INDEPENDENT AIR QUALITY REVIEW WESTCONNEX - M4 EAST

NSW Department of Planning & Environment

10 February 2016

Figure F-28 Mean concentrations at WDA M4 East monitoring sites (grey shading shows range of values at OEHL sites)

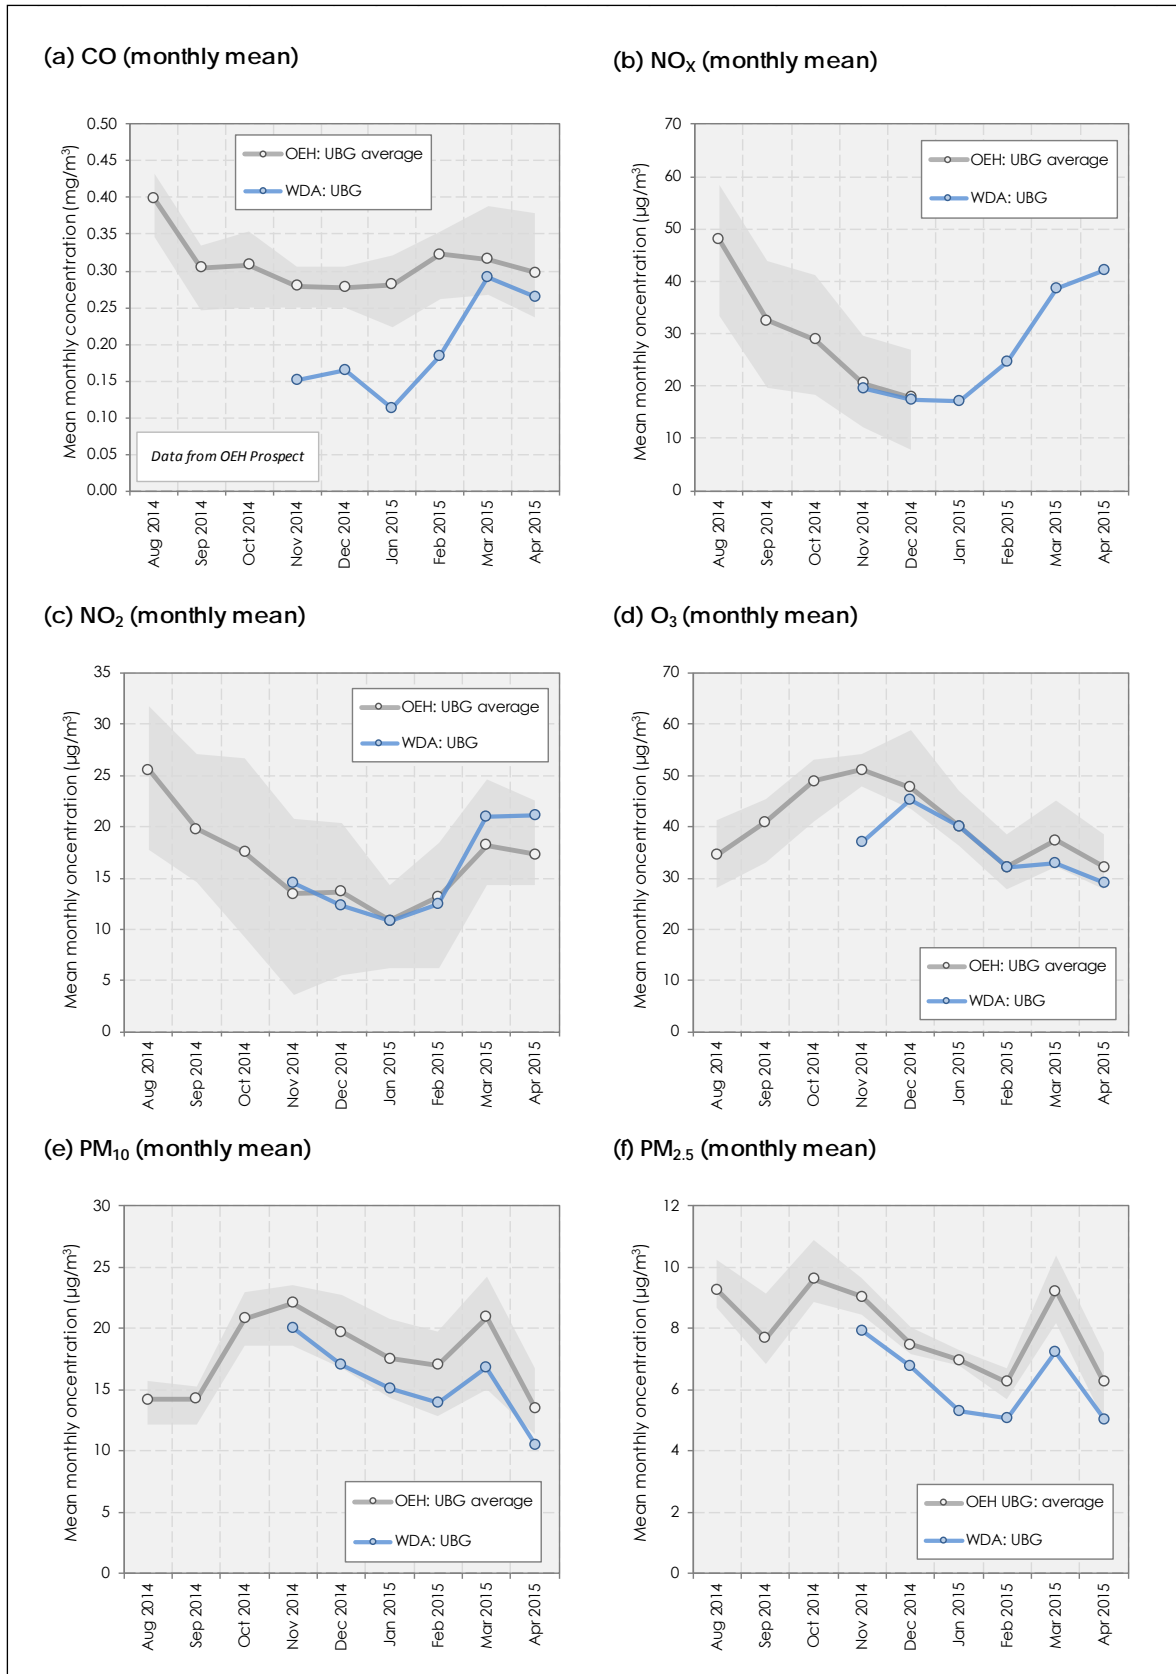
There does not appear to be any comprehensive Project specific monitoring data presented. It appears that the assessment only provides some graphical, monthly mean data from only one of the five Project specific monitoring sites, the background monitoring site at St Lukes Park station.

On the basis of this analysis, which is often for just two months i.e. two monthly average data points, the consultants deem the OEH monitoring sites are representative of background locations in the assessment.

A reasonable effort should be made to present the complete, up to date set of local monitoring data, and to conduct an analysis of the measured levels on an hourly, daily etc. basis, consistent with criteria averaging periods.

Figure F-34 Background map for annual mean NO_x concentration in 2014 (detail for WestConnex GRAL modelling domain)

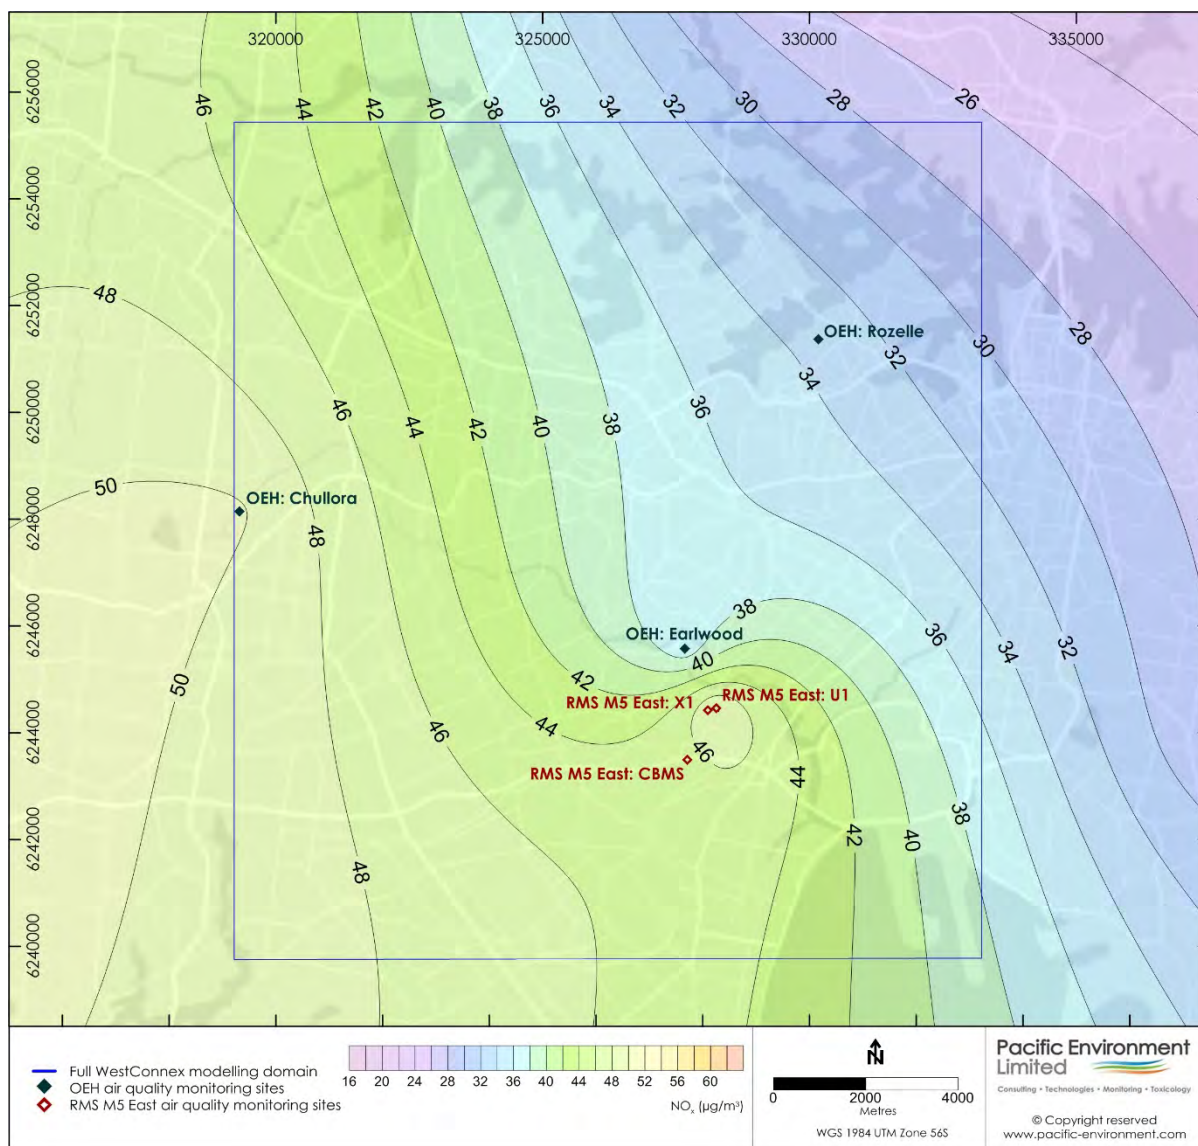
A spatially varying annual mean concentration has been used for NO₂ and PM₁₀ in an urban area, for 2014.

An analysis of the long term trends in NO₂ shows that unusually low results were recorded across the network in 2014, and the use of these data to represent the background levels is questioned.

The spatially varying grid also shows large gradients in pollutant levels at monitors that are close together in the modelling domain. The method used can introduce unnecessary errors in an assessment, such as when unrepresentative data are used and significantly skew the outcomes, for example in this case where data from the NorthConnex NC 02 monitor (which is near the intersection of Pennant Hills Road and the M2 Motorway) are used to represent underlying background levels.

Overall, it would be useful to consider using the locally measured data in a straightforward approach, consistent with the NSW Approved Methods definitions and means of accounting for background pollutant levels.

Figure H-15 Annual and diurnal plots of wind speed and temperature for BoM Canterbury Racecourse AWS, 2014

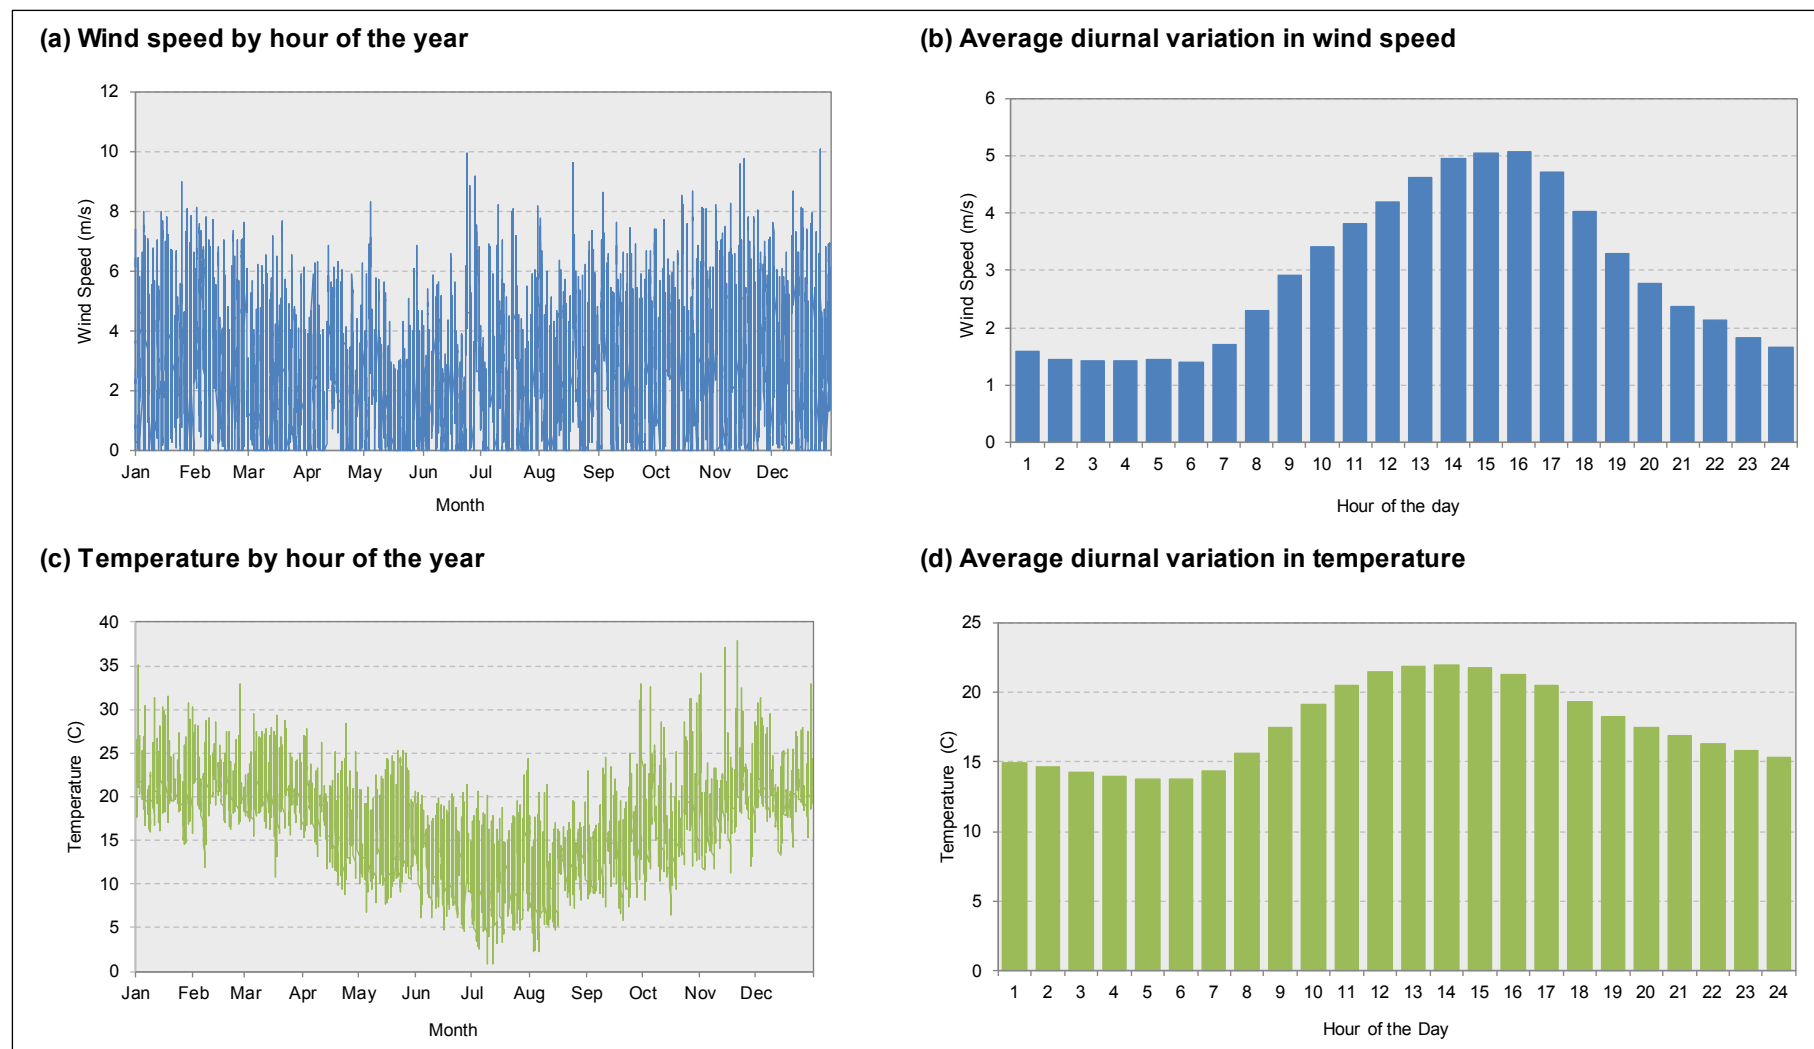
Data from the Bureau of Meteorology (BoM) Canterbury Racecourse Automatic Weather Station (AWS) during 2014 calendar year was chosen for use the modelling as: *it was the most recent year, located closest to the centre of the modelling domain and was considered representative of the general wind patterns.*

The meteorological data analysis does not provide any convincing, or reasonable justification of the choice of the data used for the modelling.

The analysis provided appears to contradict the consultant’s claimed suitability and representativeness of the data for the locality near the Project. For key metrics, such as wind speed and occurrence of calms, the consultant has selected the least representative data from the poorest performing station relative to the other meteorological stations in the vicinity of the Project.

The station recorded substantially fewer calms and much higher average wind speeds than are typical, or measured in the locality. For example, in comparison to the BoM Canterbury Racecourse AWS, the EPA Earlwood and Rozelle sites recorded lower annual average wind speeds (1.3 and 1.7, vs. 3.3 metres per second (m/s)) and a higher percentage of annual calm periods (22 and 22.1 vs. 8.6%) (refer to **Table H-1, Appendix H**).

The consultant does not appear to have considered that the latest (June 2014) BOM report for the selected Canterbury Racecourse station shows that the weather sensors were last replaced in 1995 with mechanical instruments.

Figure H-16 GRAMM predicted and observed hourly average wind speed (time series, regression and percentile plots)

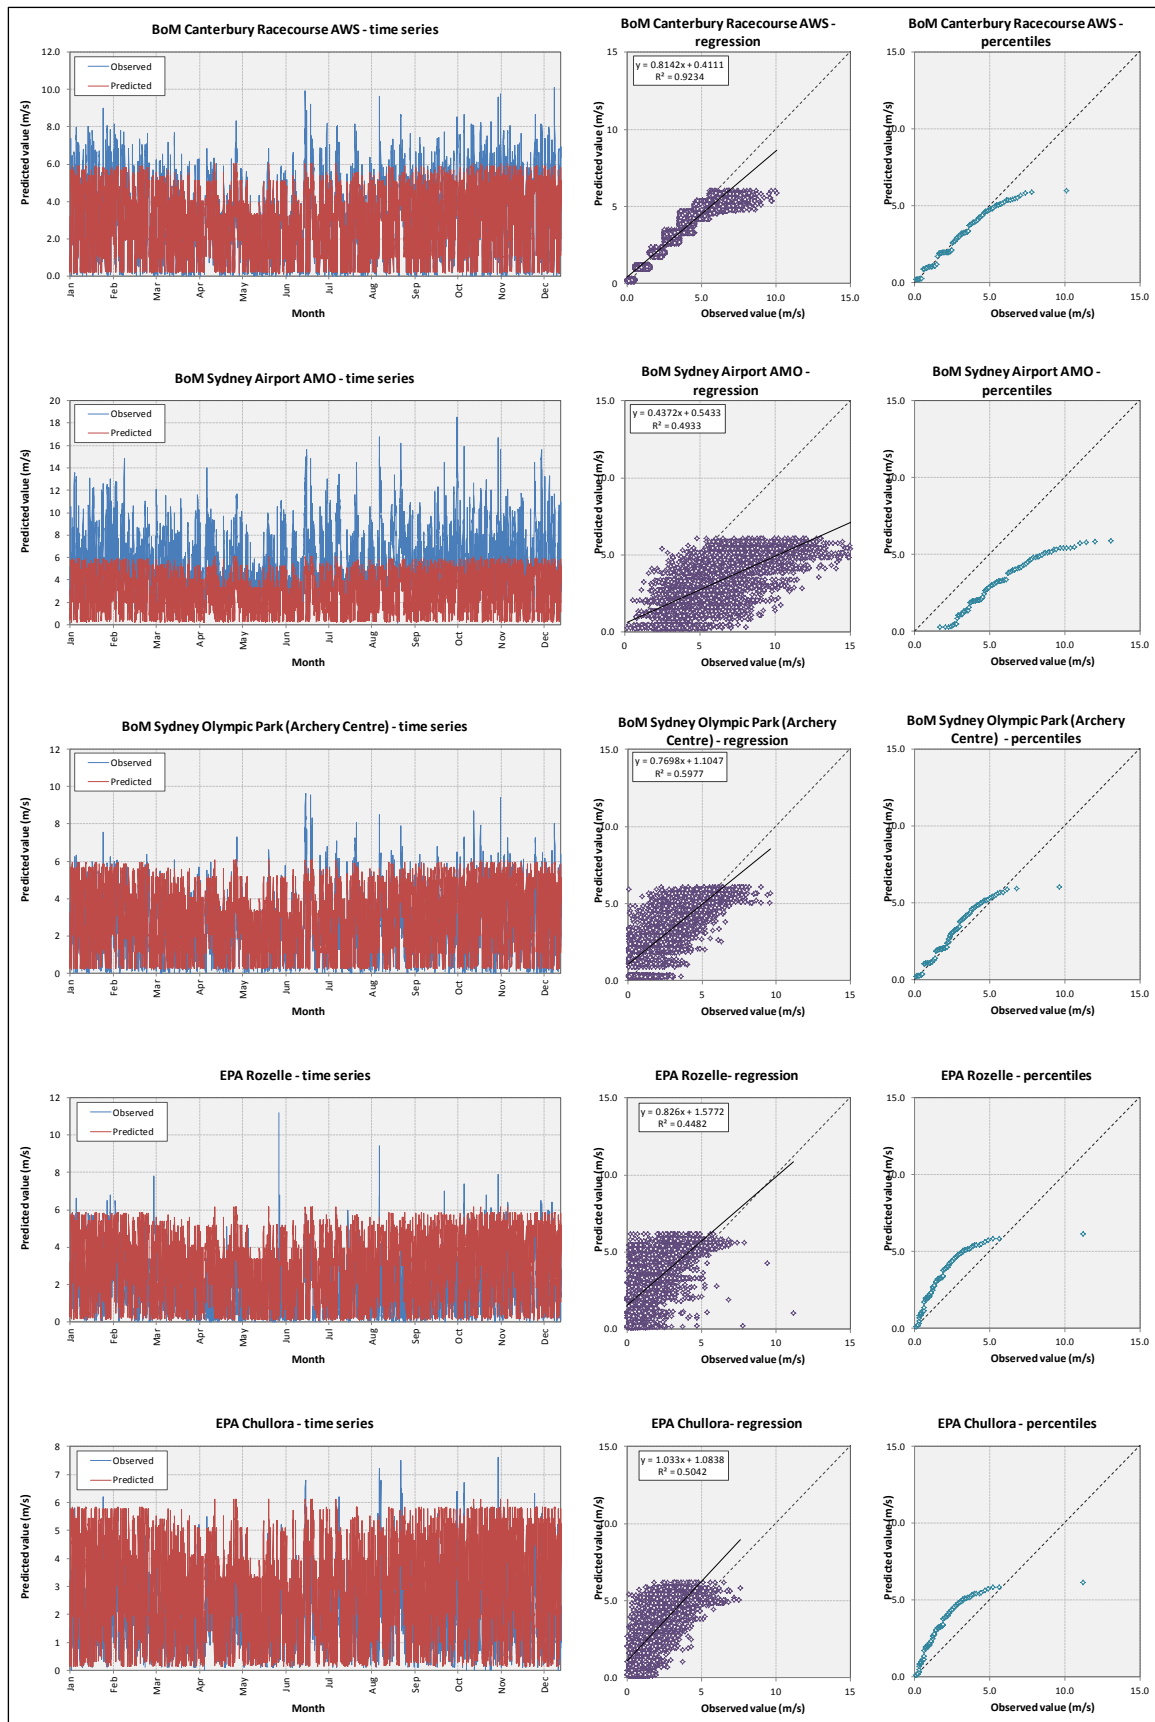
The correlation between the GRAMM predicted wind speed with actual measured data shows good overall correlational at the chosen meteorological monitoring station site (except for wind speeds above 5m/s where the correlation is poor). However perfect correlation would normally occur for this type of analysis, which indicates that the overall inherent inaccuracy of the GRAMM modelling data is at least approximately 8% (i.e. $R^2 = 0.92$), but is larger at higher wind speeds.

Overall, the model performance is considered poor (by contemporary standards), possibly due to a poor modelling approach and poor data selection.

Figure 8-16 Modelled discrete receptor locations

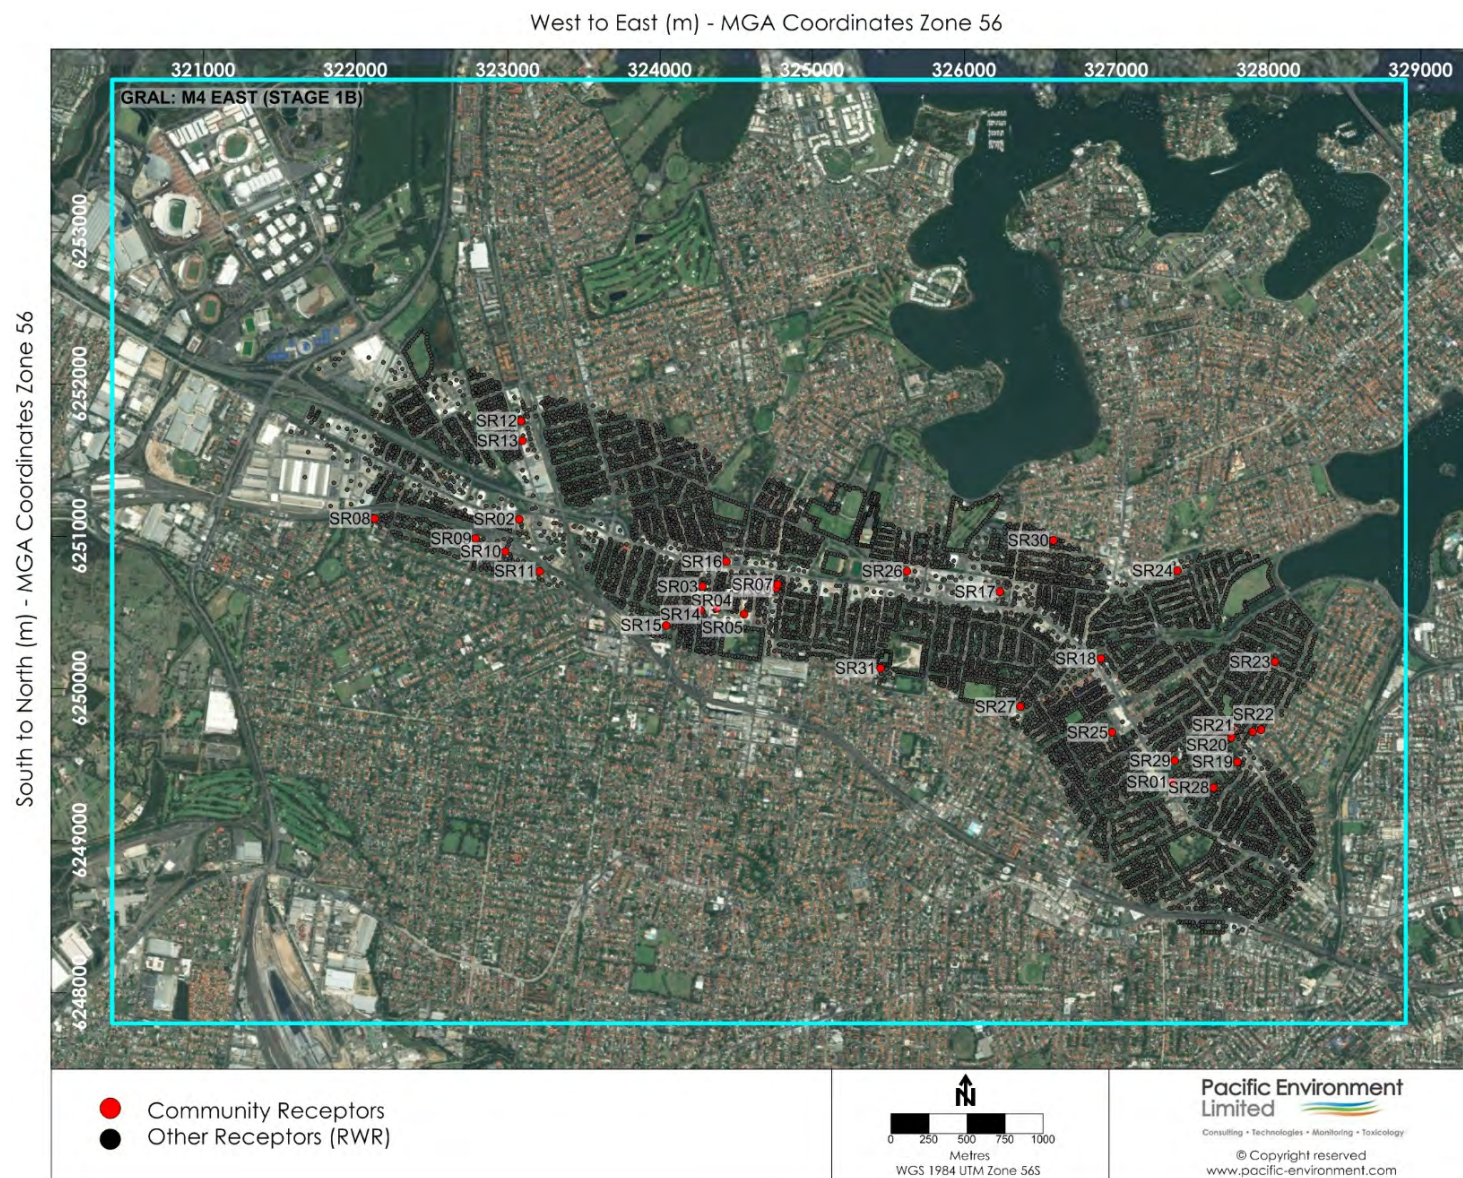
The receptor selection appears to be significantly biased towards receptors located further from the road, with a significant underestimation apparent in the number of receptors near to the road. Whilst generally most receptor localities are included, there are several aspects in the assessment that would bias the results, and consequently may affect the health risk assessment (outside the scope of the air quality review).

The number of dwellings on several residential blocks some distance from the road were counted and it was found that there are many more receptors than actually exist. The assessment includes many more receptors than there are dwellings along the streets, additional rows of receptors are added between rows of houses, and in some cases rows of receptors are included along small lanes and local roads. Overall, it was estimated that approximately 50% more 'Residential, workplace and recreational (RWR) receptors' (than actual dwellings) appear to be included in the assessment for the locations away from the road.

For receptors near the road, large multistorey apartment buildings are represented by a single RWR receptor, generally in the centre of the building, whereas there appear to be many, possibly dozens of apartment dwellings within these buildings, some of which are only metres from the road. There appears to be a large underestimation in the number of dwellings in this regard. For some of the locations this could be an underestimation by a factor of ten or more in the number of actual sensitive receptors.

The same situation appears to apply for the large office buildings, and some of the largest are not included in the assessment at all. Some of these offices have outside parking lots containing many hundreds of cars, indicating many hundreds of people would be present during the day when there are likely maximum pollutant emissions.
